DRB Application No.: 08DRB-70443 Project # 1007521  
 Project Name: EAGLE ROCK ESTATES UNIT 3  
 Agent: SHAKEEL RIZVI Phone No.: 315-6563

08DRB-70441 VACATION OF TEMPORARY PUBLIC EASEMENT  
08DRB-70443 MINOR - PRELIMINARY/ FINAL PLAT APPROVAL

SHAKEEL RIZVI request(s) the referenced/ above action(s) for all or a portion of Lot(s) 15-17, Block(s) 2, **EAGLE ROCK ESTATES Unit(s) 3**, zoned RD, located on the southwest corner of EAGLE ROCK AVE NE and OBSEDIAN ST NE containing approximately .25 acre(s). (C-18)

PLAT OF  
 LOTS 15 THRU 17  
 BLOCK 2  
 UNIT 3  
 EAGLE ROCK ESTATES  
 WITHIN THE  
 ELENA GALLEGOS GRANT  
 PROJECTED SECTION 13  
 TOWNSHIP 11 NORTH, RANGE 3 EAST, NMPM  
 CITY OF ALBUQUERQUE  
 BERNALILLO COUNTY, NEW MEXICO  
 SEPTEMBER, 2008

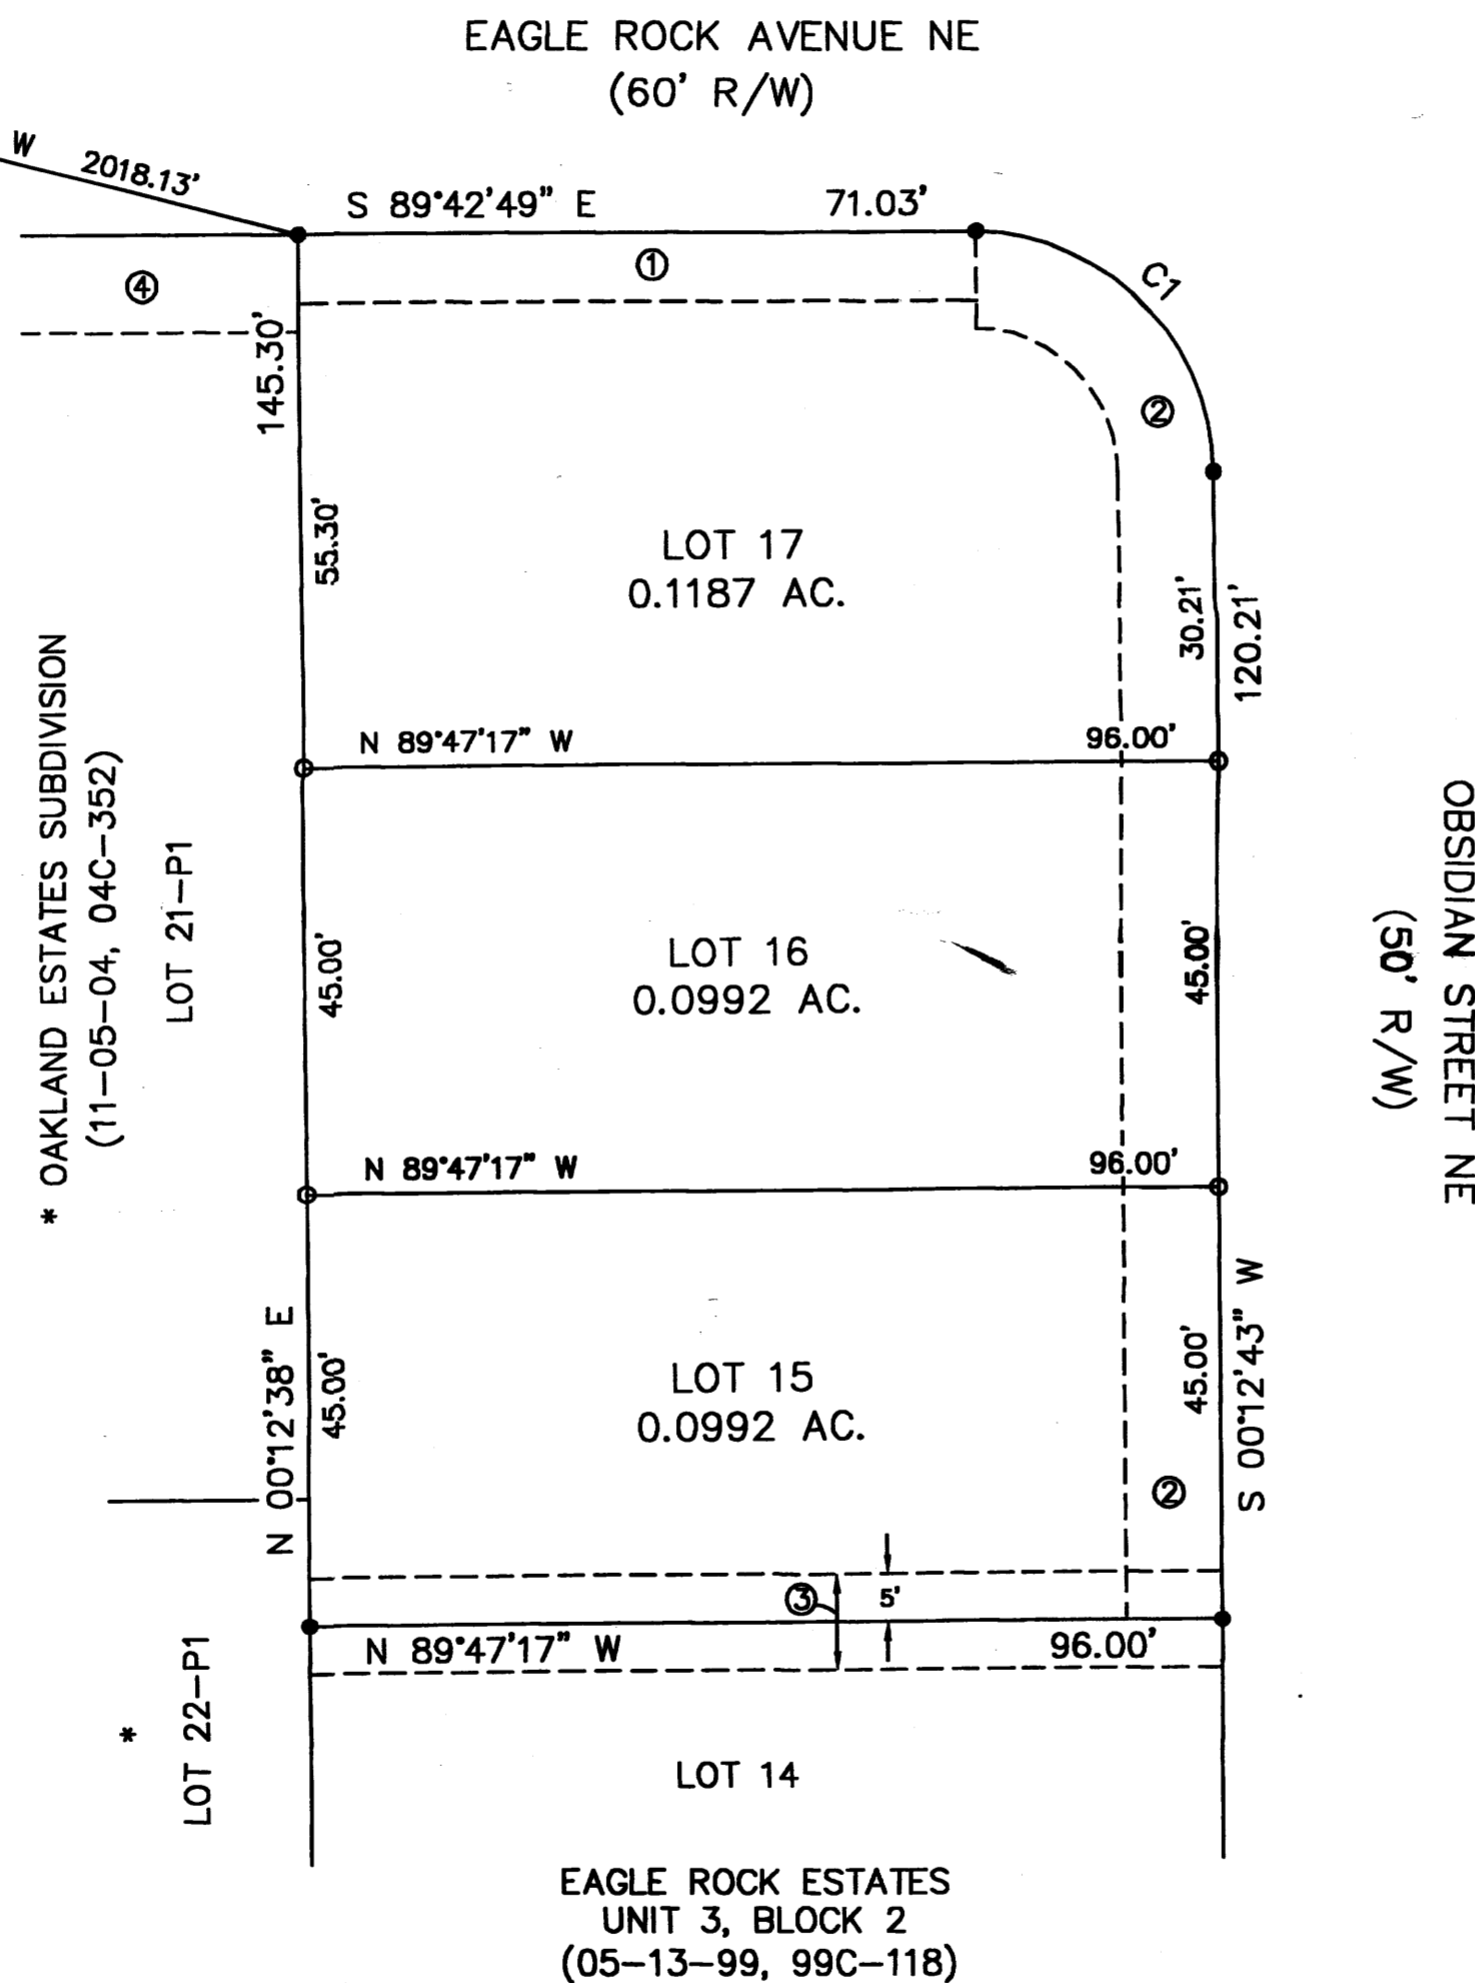
Please remove Zoning Note (#8) from plat. Please provide a note consistent with Section 14-7 of the Subdivision Ordinance which is specific to this type of request, i.e. use the words "THIS PLAT" (rather than the words "REQUESTED FINAL ACTION") at the beginning of the note, and not use the words "OR SITE DEVELOPMENT PLAN FOR SUBDIVISION" at the end of the note.

Drawn By: ECM/JPA	Date: 09-30-05
Checked By: TA	Drawing Name: 02089B3.DWG
Job No.: 02-089	Sheet: 2 of 2

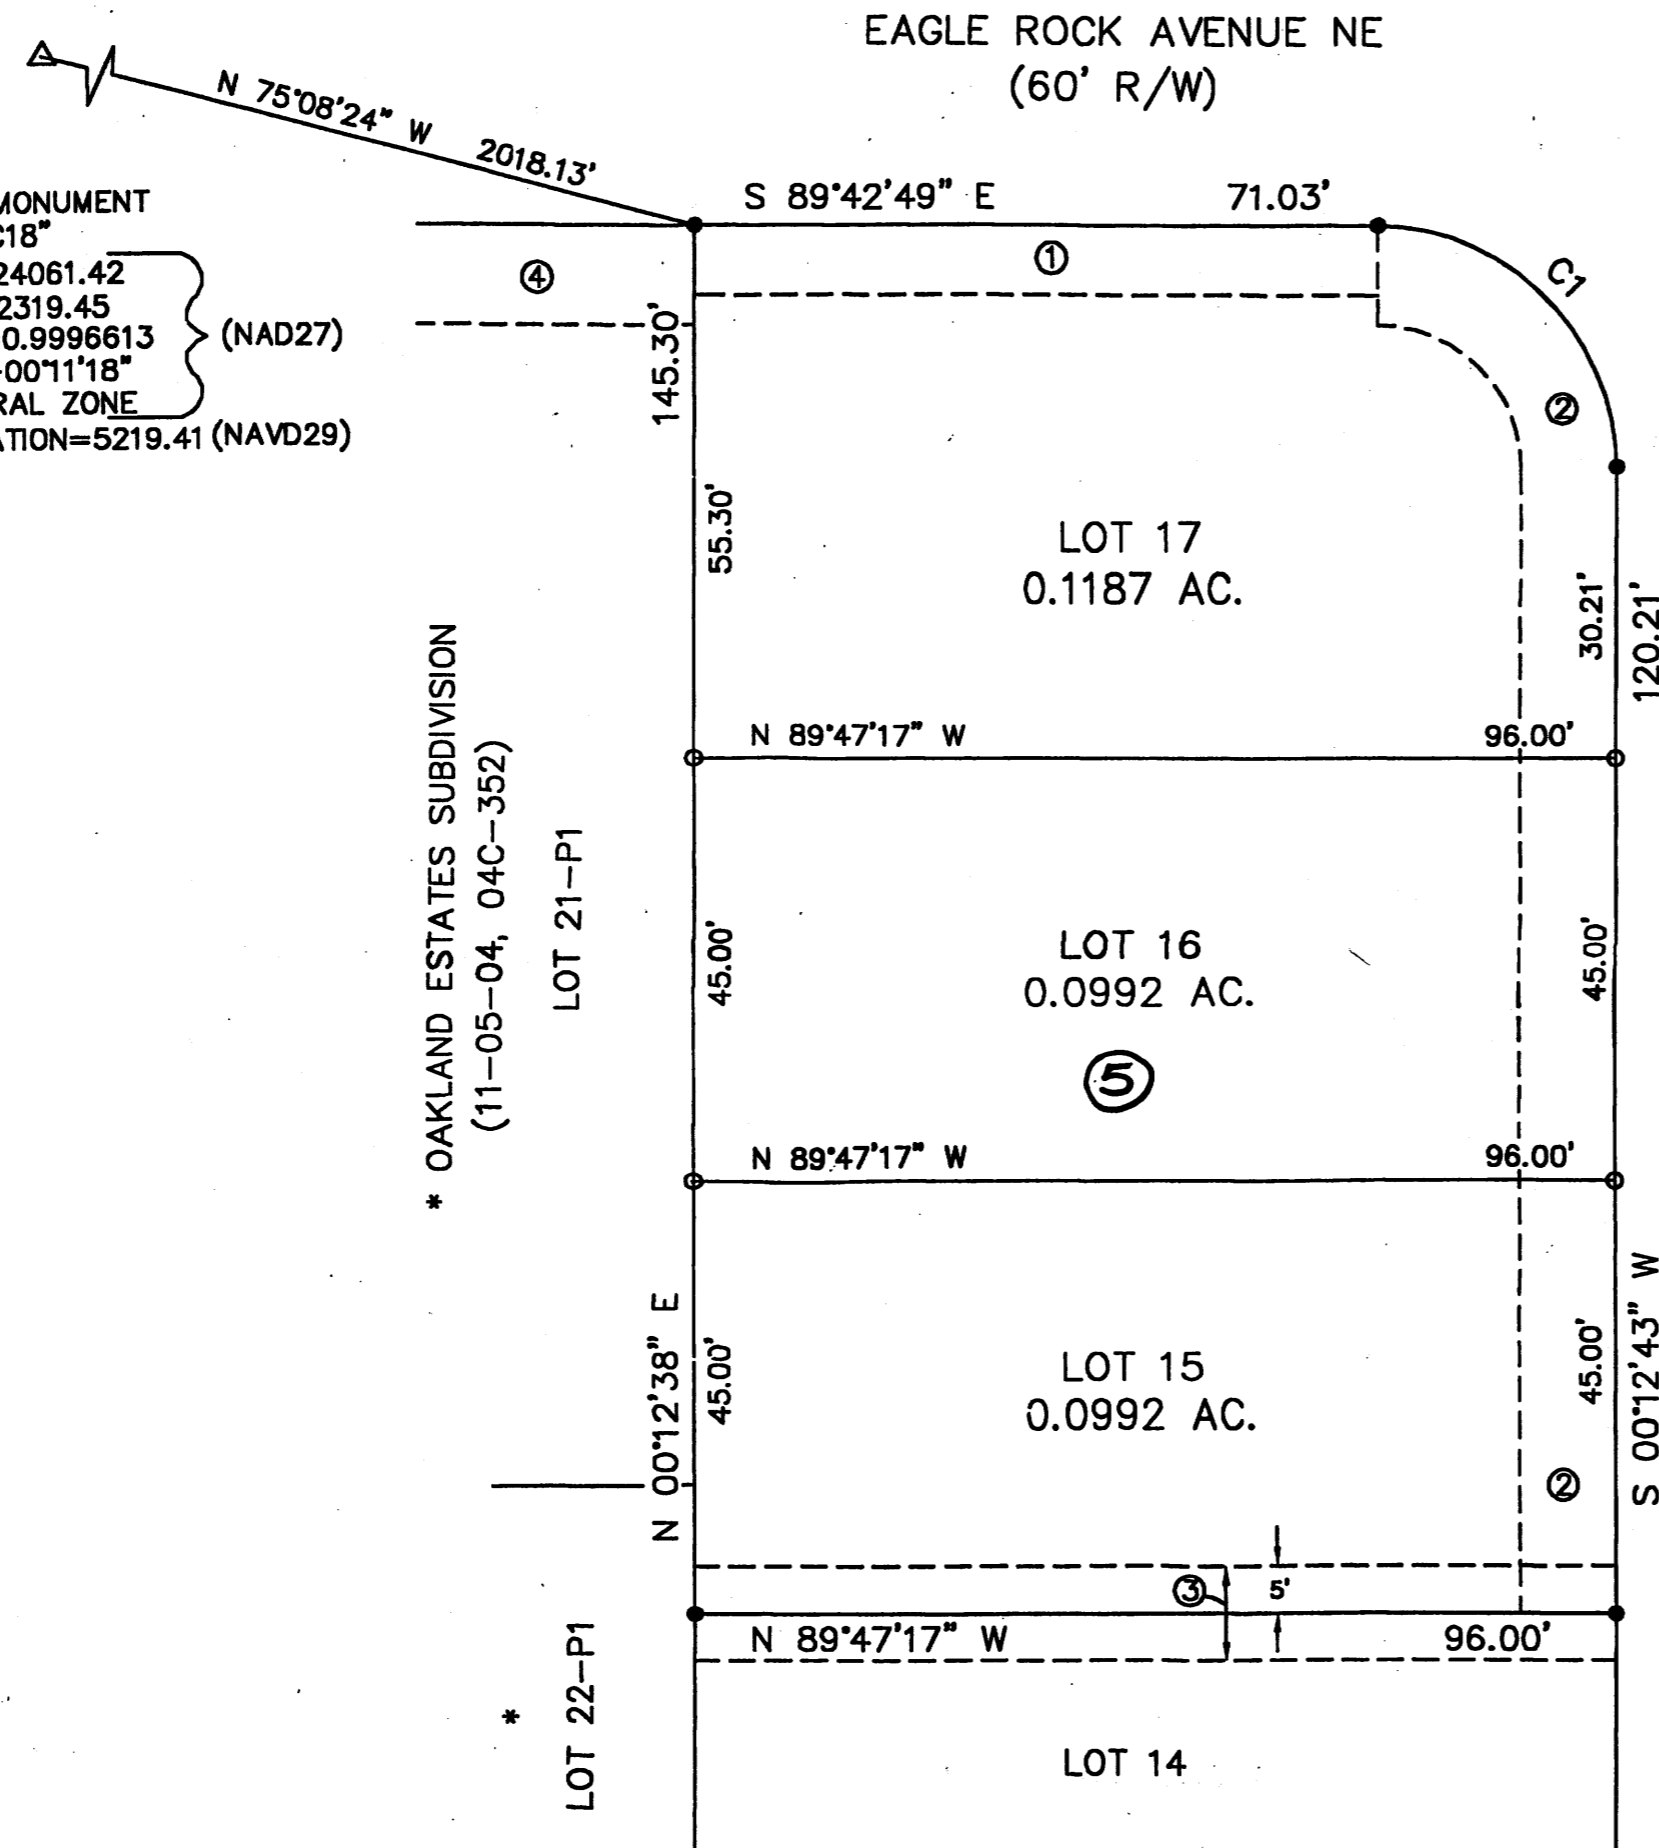
A vacation exhibit is required.

Provide an exhibit showing the location of sidewalk and defining the distance from face of curb to the property line. Right of way dedication may be required.
